**Laurie Leader - RE: BP#2014-01953 85 Morning Street - Plan review**

**From:** Laurie Leader [mailto:LRL@portlandmaine.gov]  
**Sent:** Tuesday, September 23, 2014 3:05 PM  
**To:** leaton@mymainerental.com  
**Subject:** BP#2014-01953 85 Morning Street - Plan review

85 MORNING ST

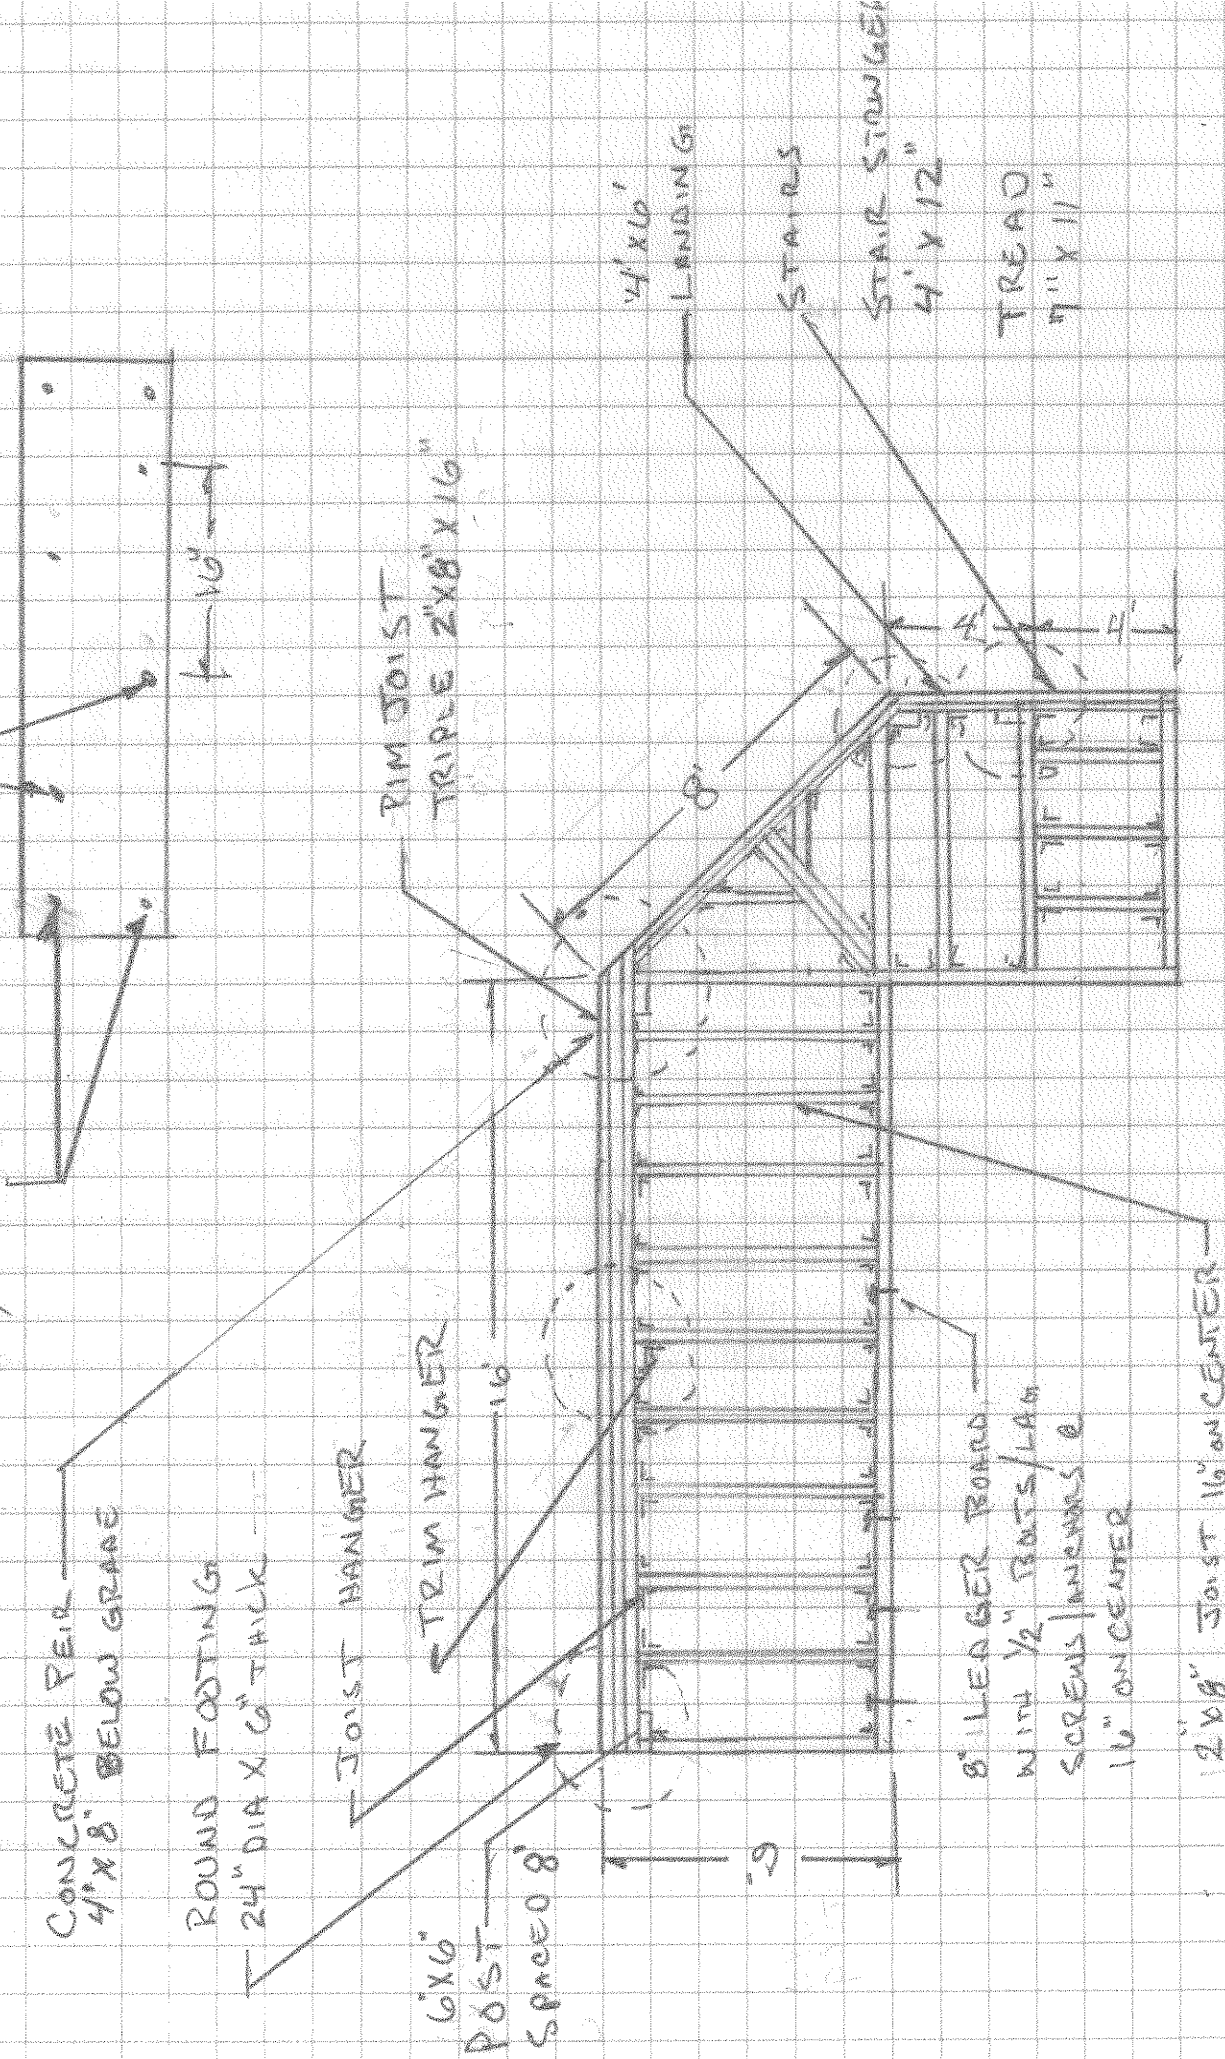
1. Foundation plan with location and depth of pre-cast concrete piers or sonotube.- 4'
2. Anchor bolt size- 1/2"
3. Post to beam attachment detail and post sizing. 6X6"
4. Typical deck framing plan for all levels of deck including size and spacing. Attached should help with this.
5. Attachment detail of ledger board to house. 1/2" Lag
6. Front view detail sent is difficult to read. Please resend and darken. See attached
7. I do not see stair drawn from third floor down to ground level. Verify if there is a stairway that exists for 3rd and 2nd level to ground floor. Photos of the existing deck would be helpful.- No stairs necessary from 2<sup>nd</sup> and 3<sup>rd</sup> floors. None in existence now.
8. Provide opening limitations of railings.- 4"
